HOMESTEAD AT STERLING RANCH FILING NO. 1

STREET IMPROVEMENT PLANS

NOVEMBER 2017

SF-17-025

NOTE & DETAIL SHEET

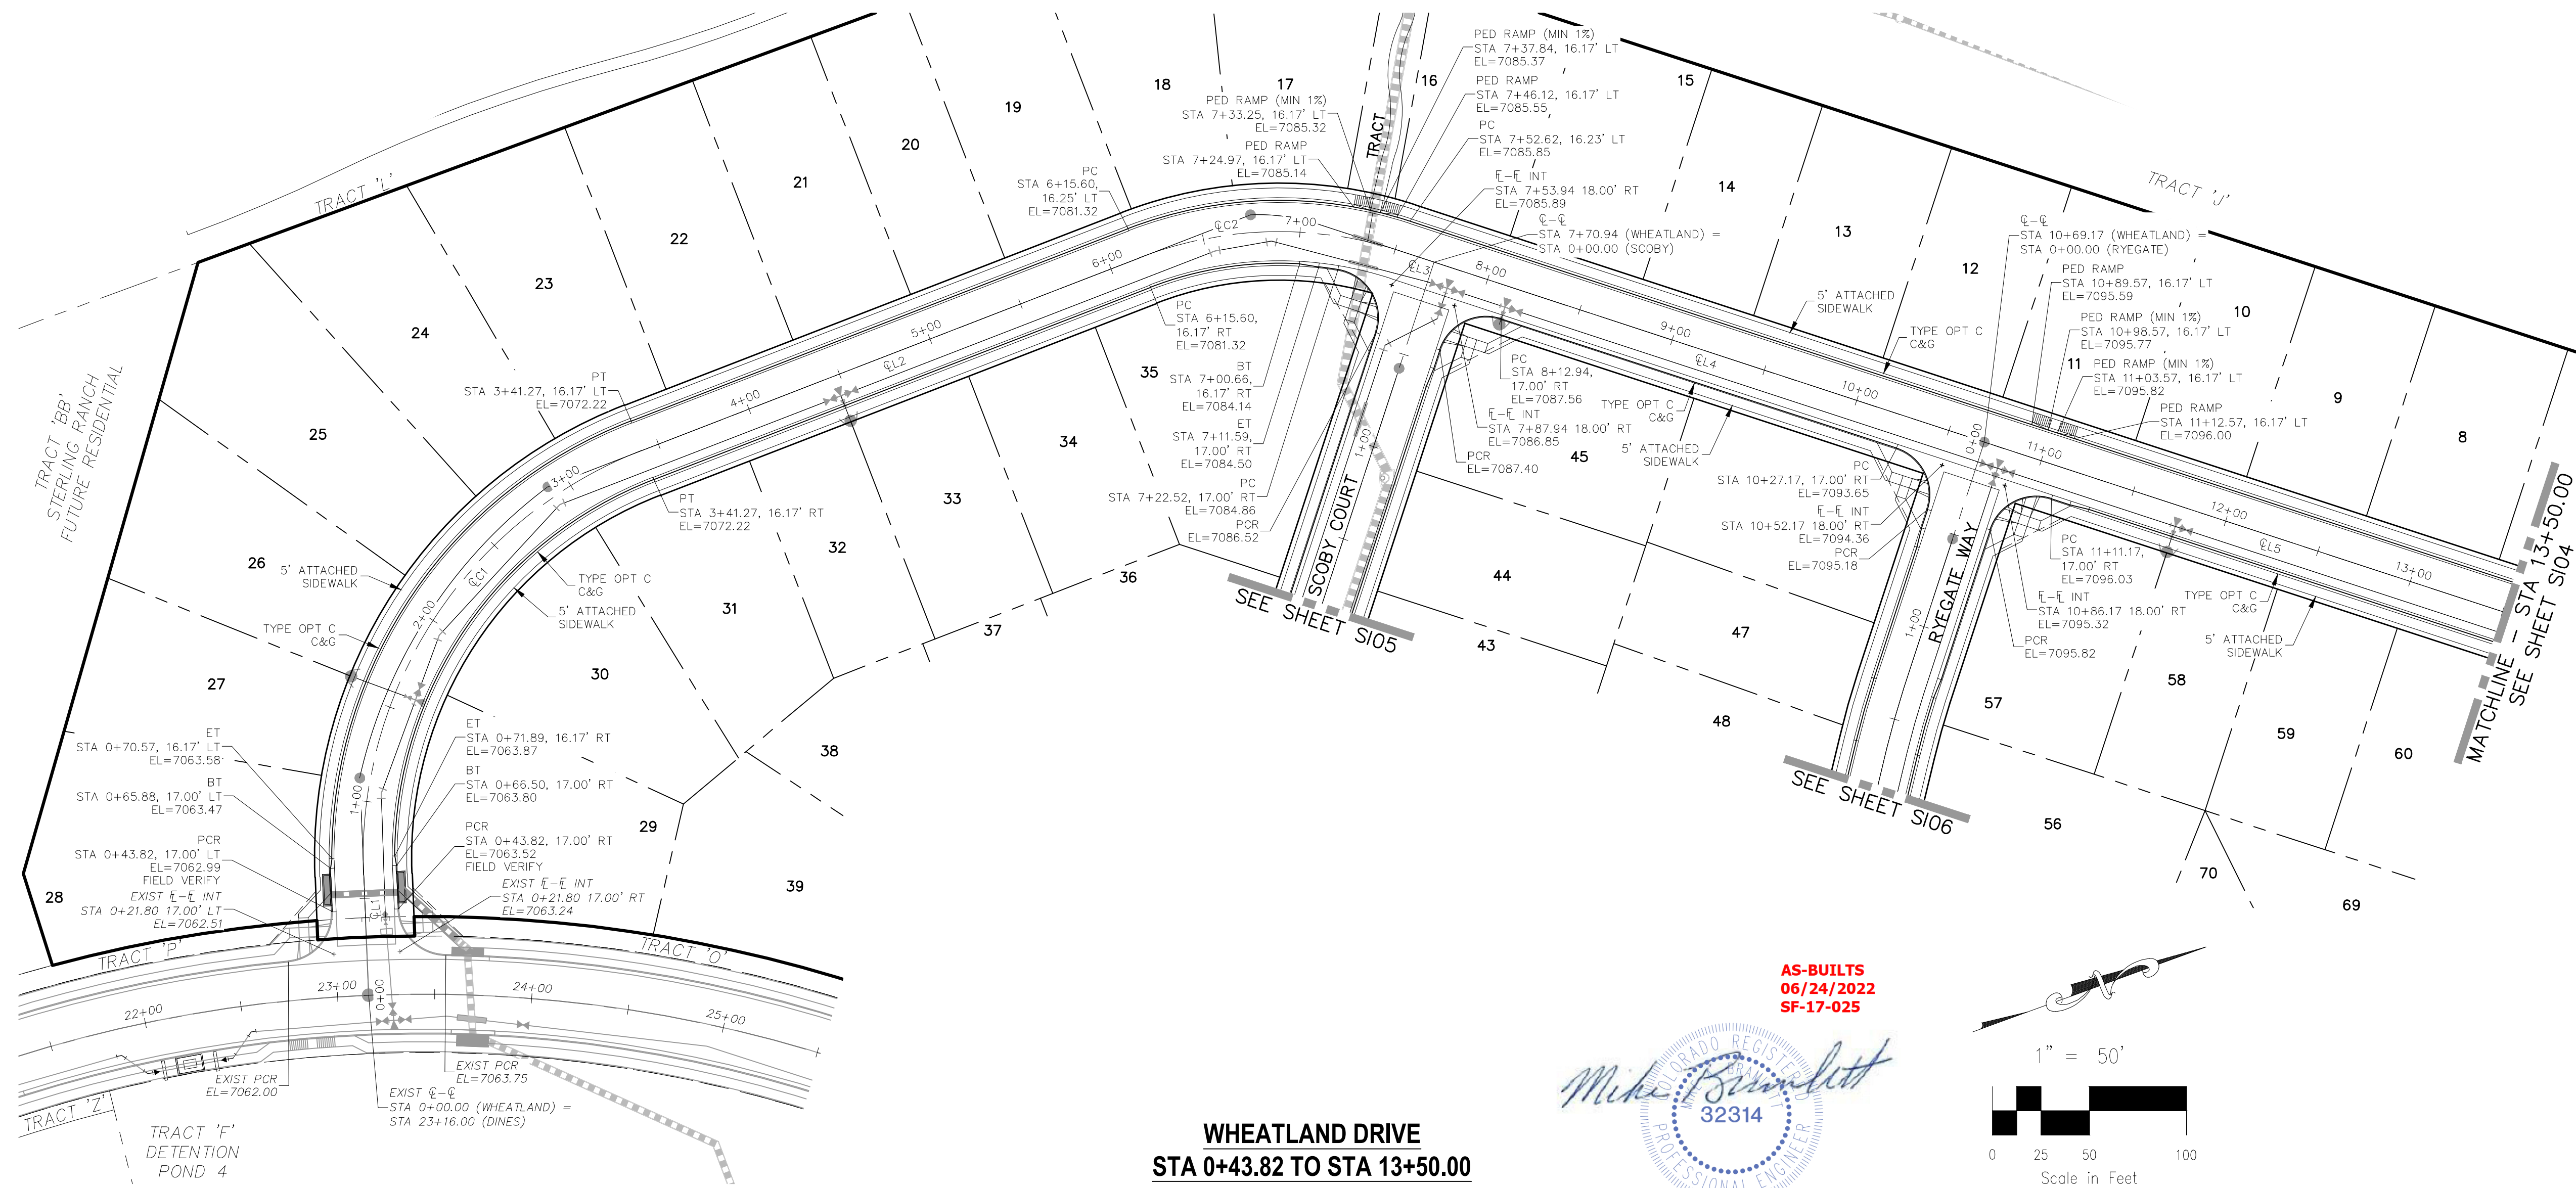
Revise all references to DSD to be PCD and DOT to be DPW.

Type C or Optional Type C (recommended)?

SCOOBY COURT
STA 0+18.00 TO STA 3+52.73

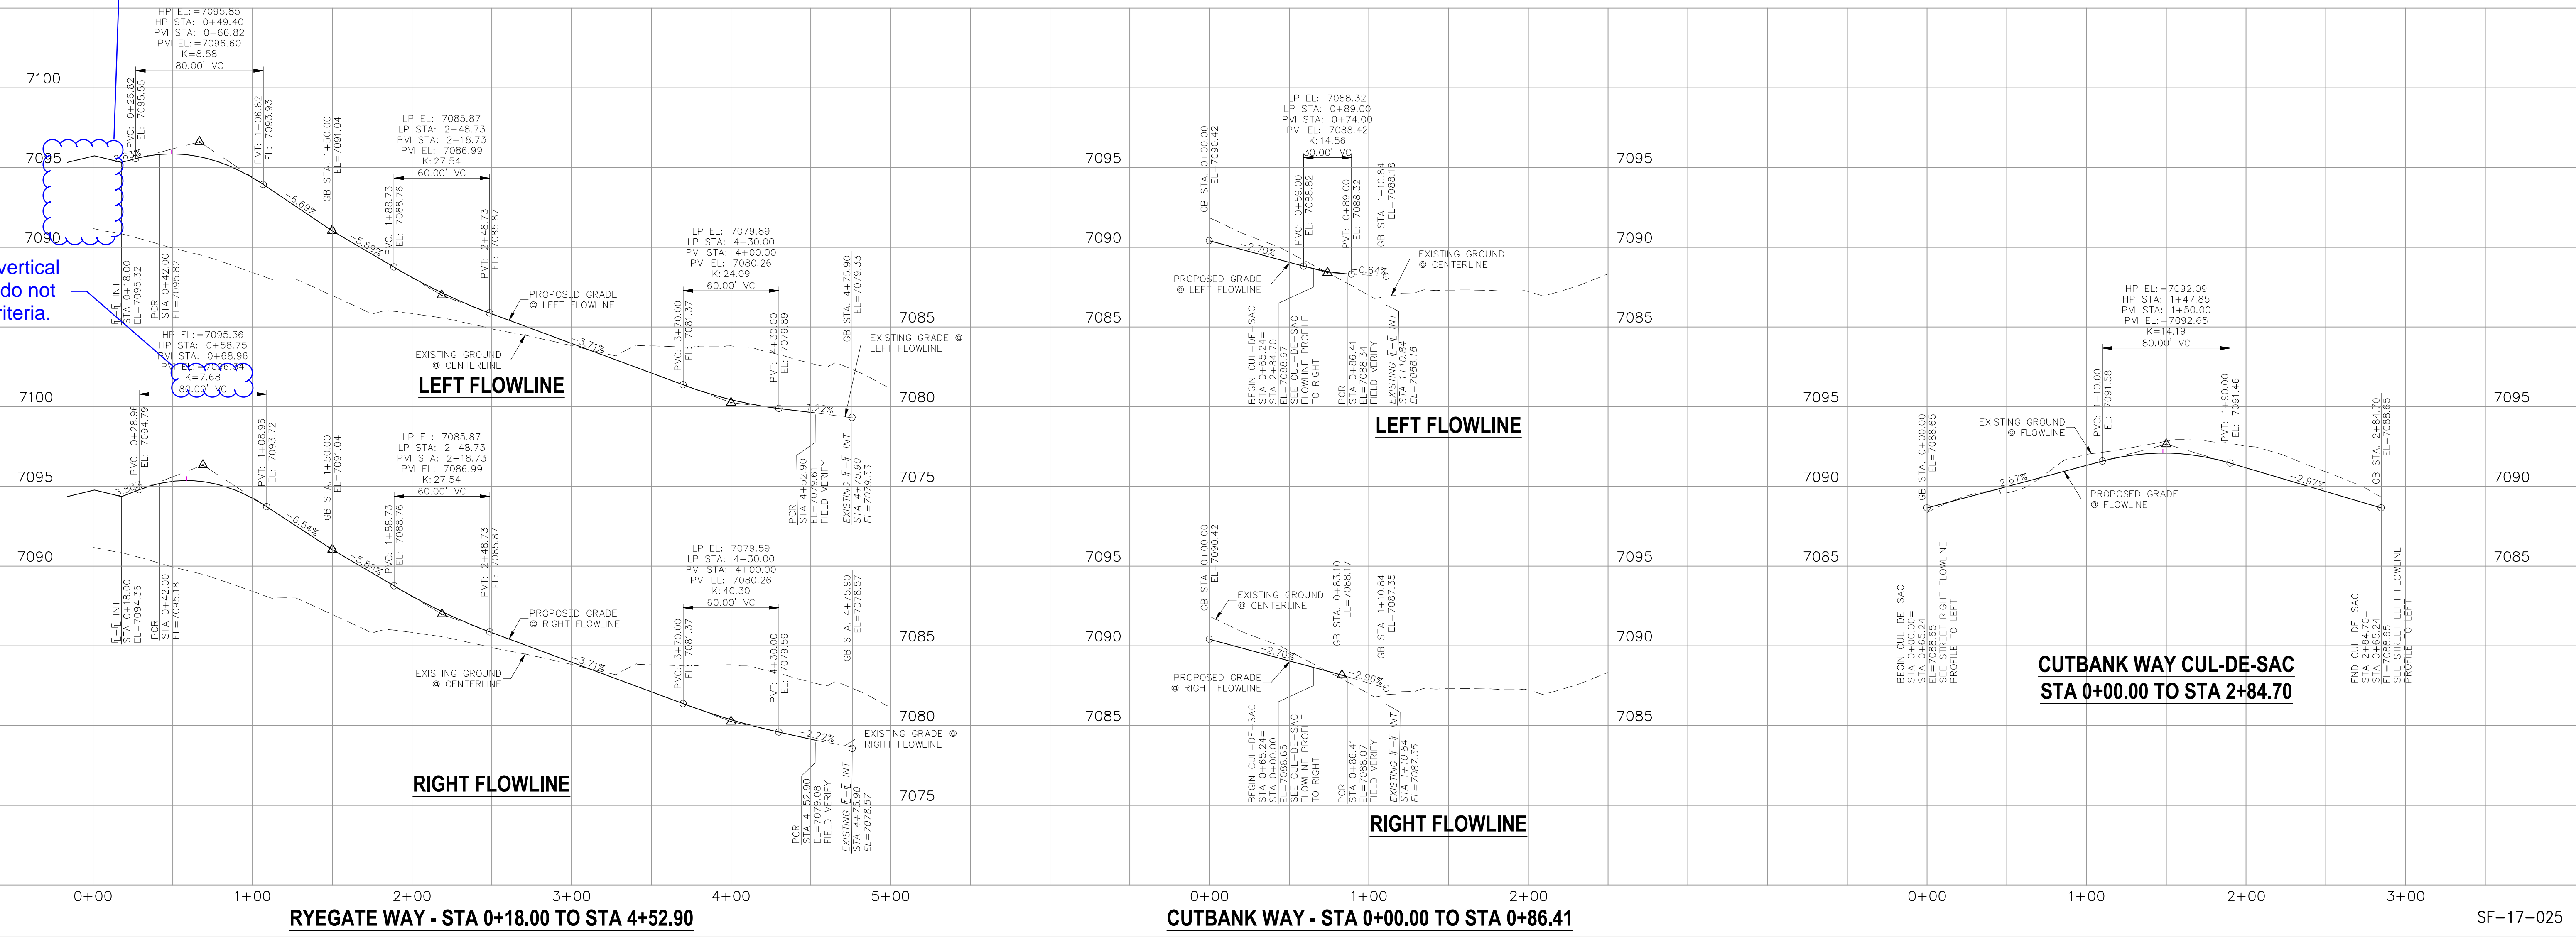
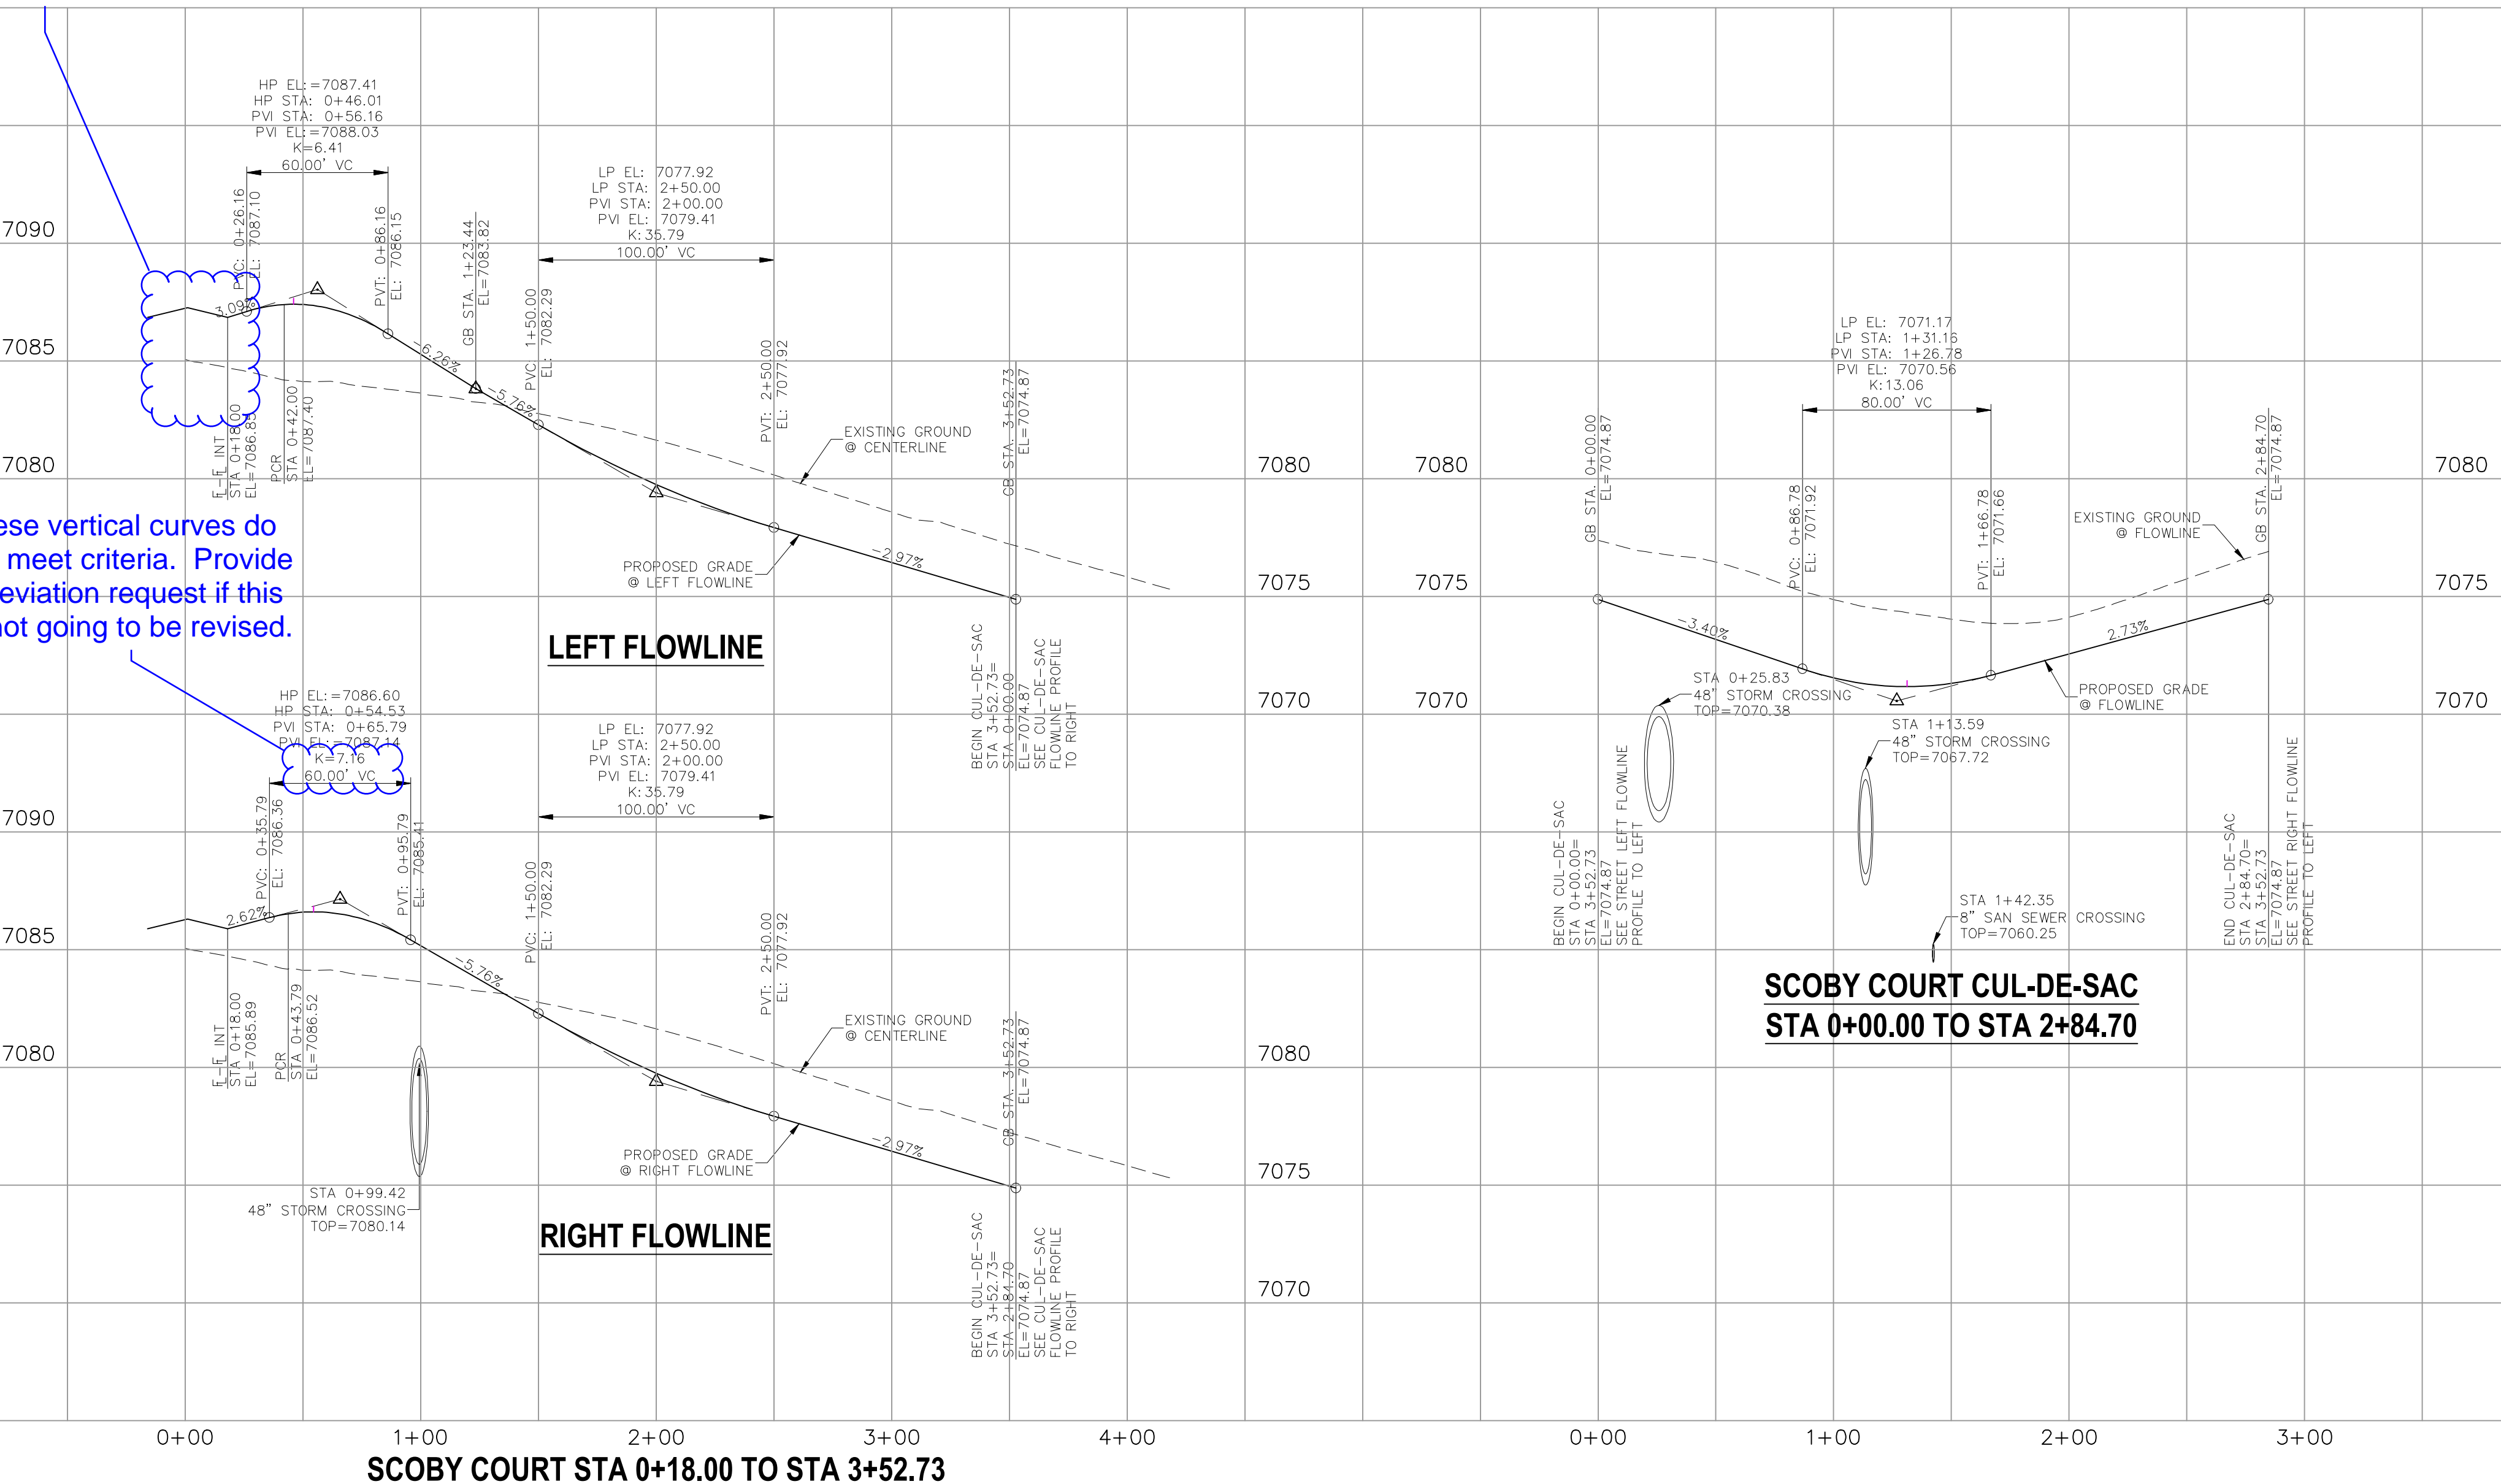
Show grades tying in at all ends of profiles

These vertical curves do not meet criteria.
